From: Caitlin Cameron
To: Fraser, Jean
Date: 1/22/2014 4:50 PM
Subject: 118 Congress Street comments - PB hearing 1/28/14

Because of the building's size, design strategies which include variation and articulation are important. I continue to feel, as in my previous comments, that the project is successful in this regard in its use of materials, fenestration, variation in roof line and form, and the incorporation of landscape elements such as green screens and rain gardens. The East and South elevations have improved in response to workshop comments. Staff has two further comments/suggestions regarding 1) Retail storefront and 2) Building overhangs.

1 NORTH ELEVATION
1/8" = 1'-0"

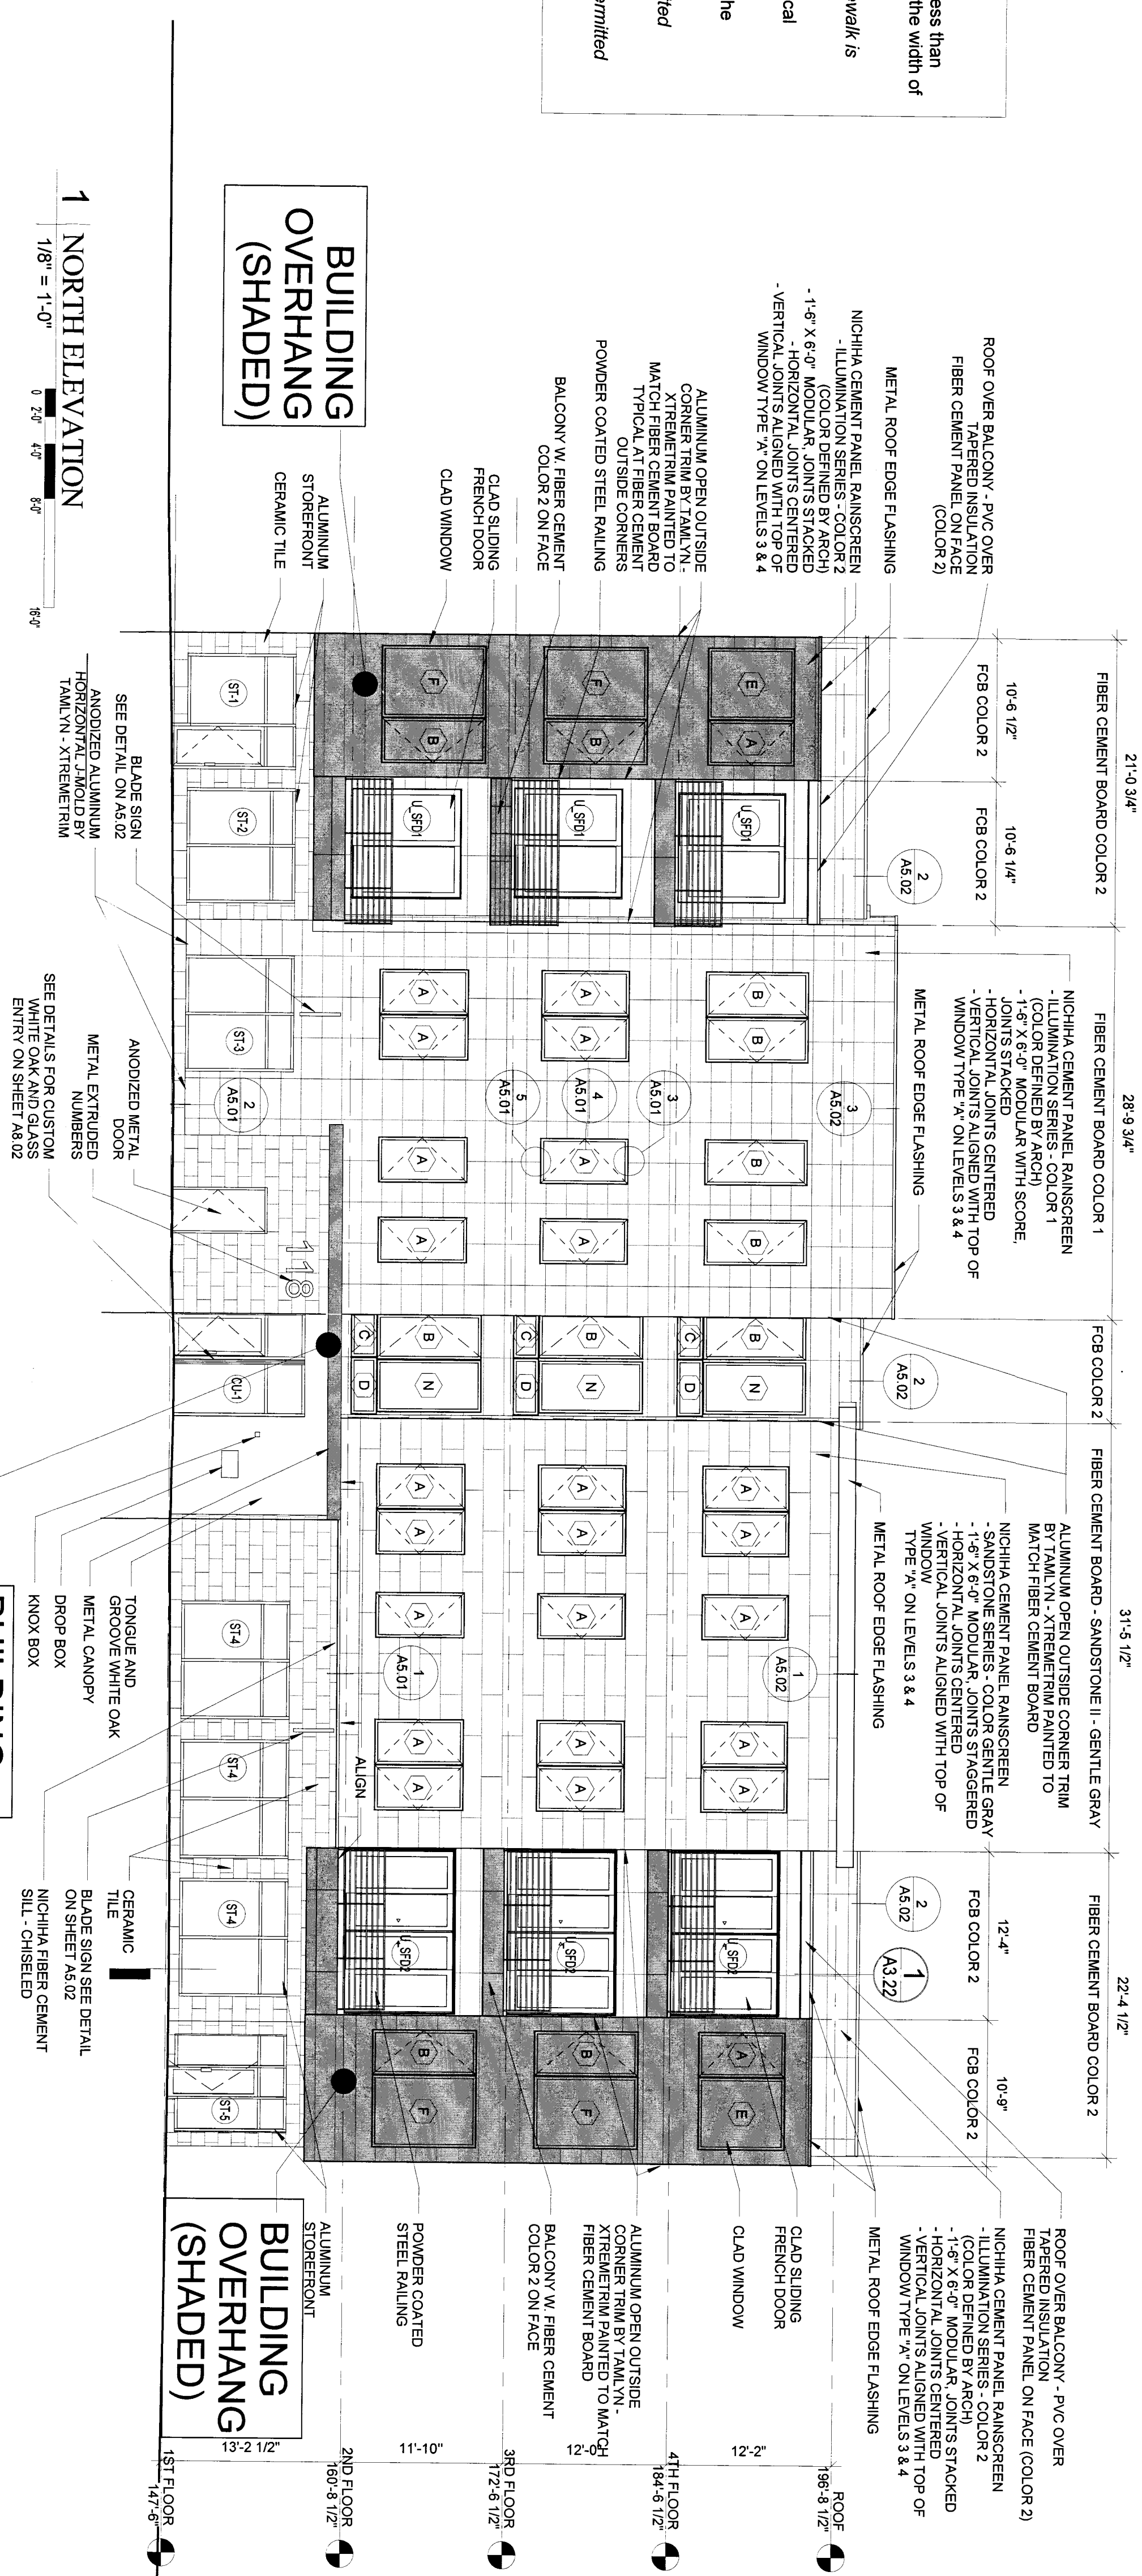
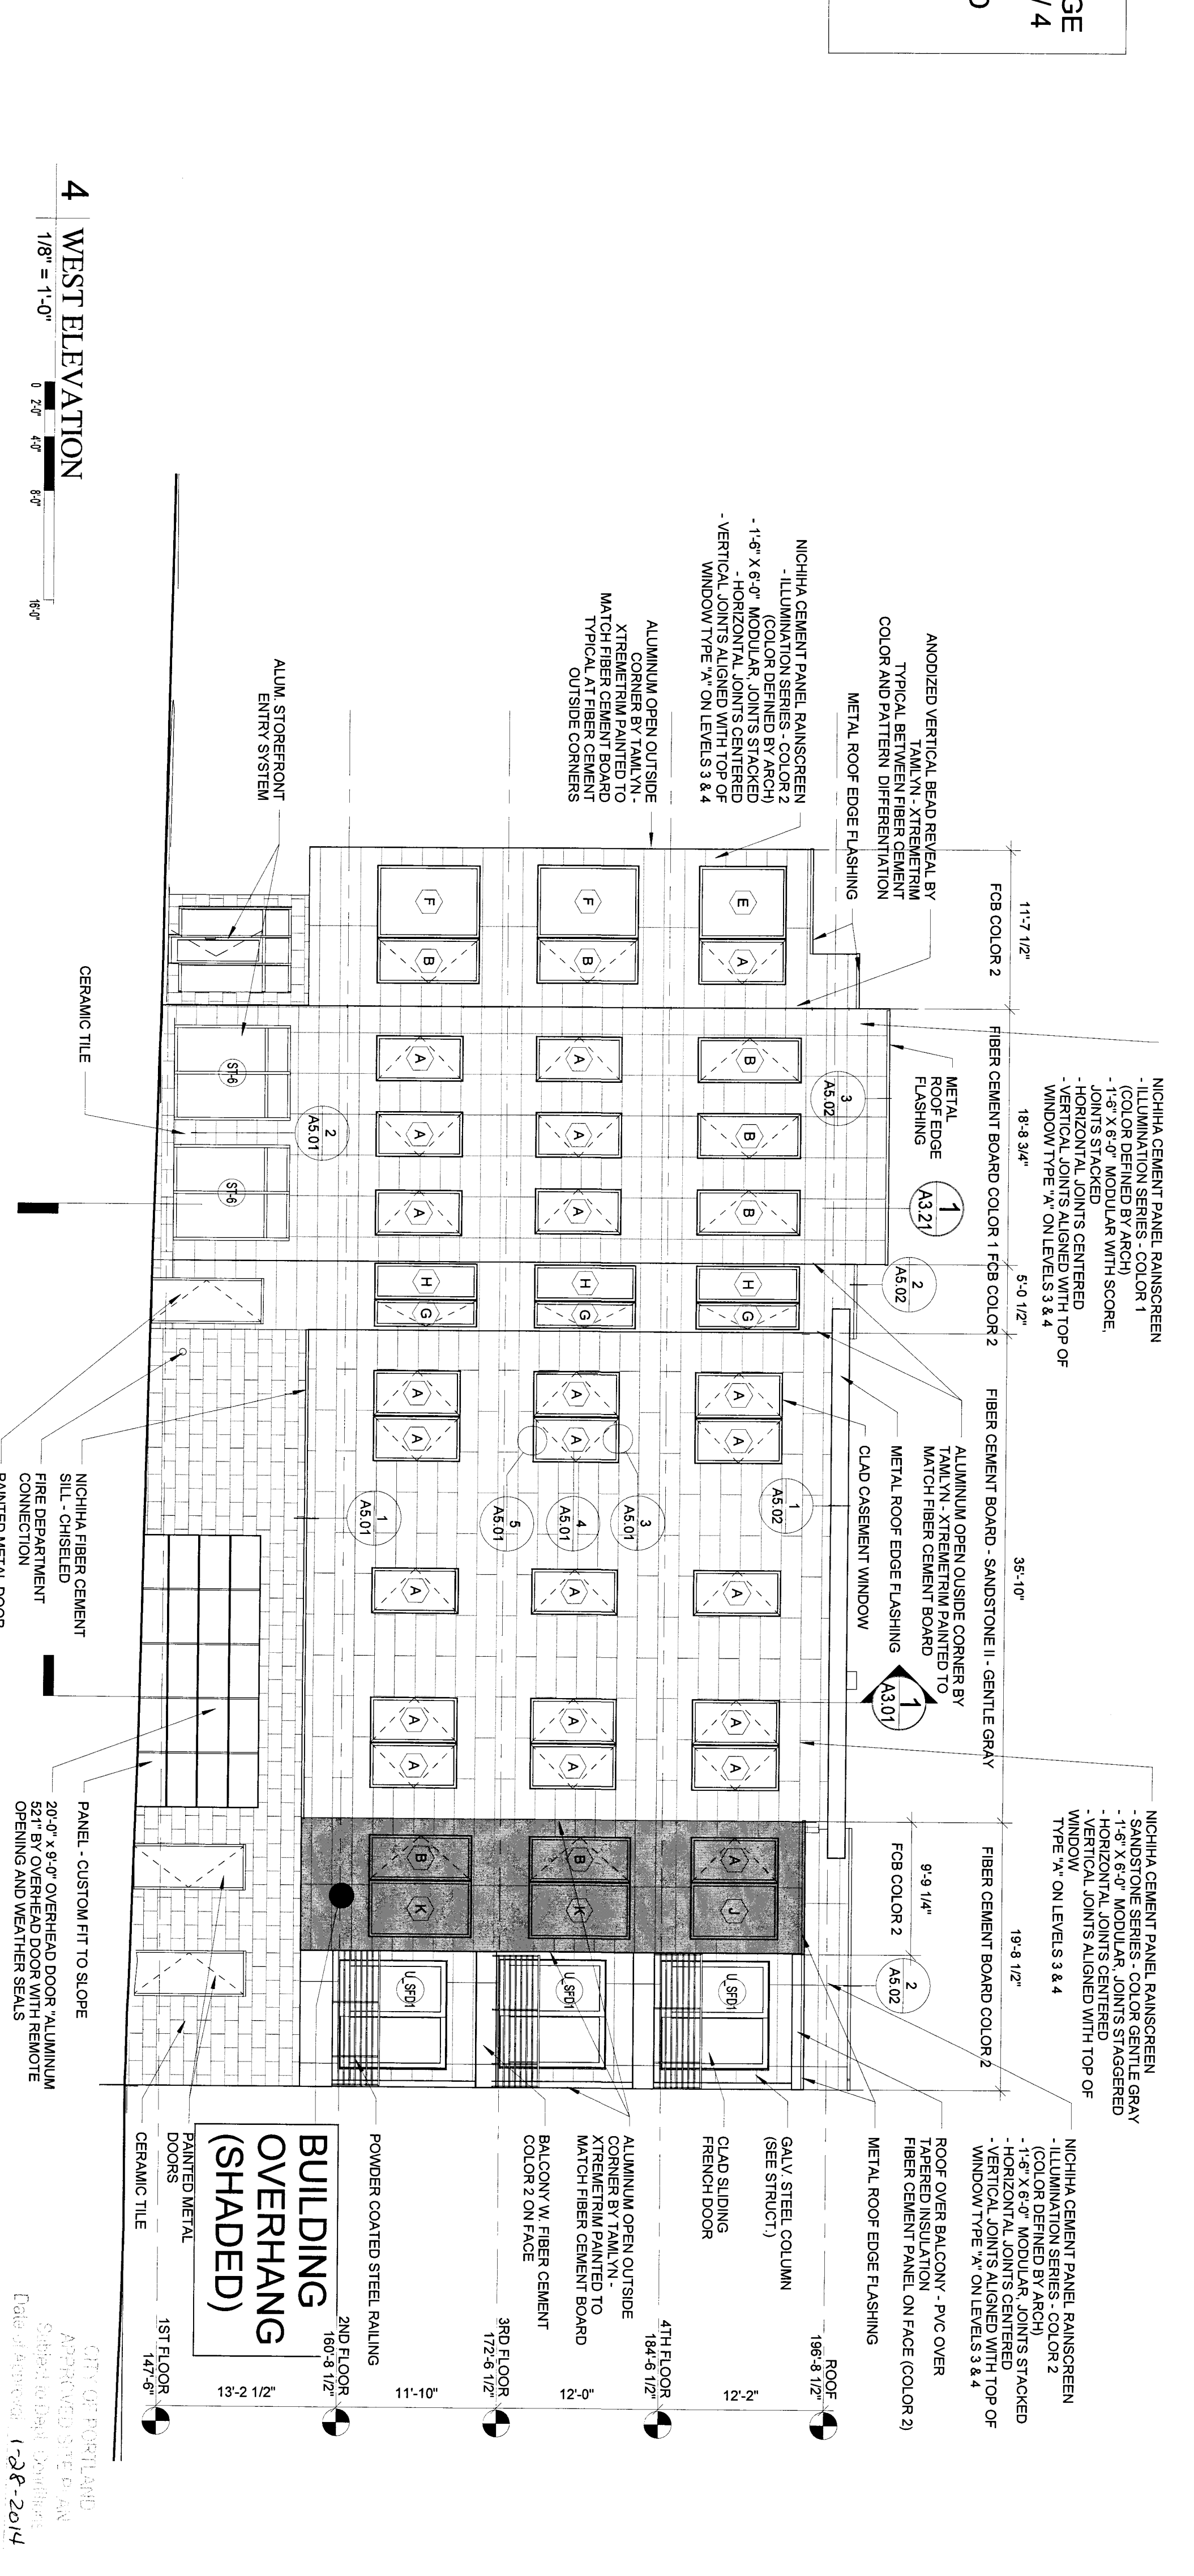
The mixed-use project will ideally enhance the street wall with its active retail storefront windows and close proximity to the sidewalk. It is for that reason staff would like to see the retail storefront window returned to the East elevation which has been removed in the latest iteration of the design. For urban design reasons, any additional landscaping would be more appropriate as vertical gardens or in the furnishing zone of the sidewalk along with the street trees rather than adding landscape elements to the retail facades.

In regards to the architectural elements proposed to overhang the public right of way, unlike other exceptions where this kind of easement over the right of way was granted, this project is not limited by site constraints, existing structure, or by maintaining historical character. The articulation of the facade is a benefit to the streetscape and produces a good design that meets the design standards. If the Planning Board decides that the overhangs into the public right-of-way are not appropriate, then staff would encourage the resulting design solution maintain the current quality of design in regards to facade articulation and variation of form.
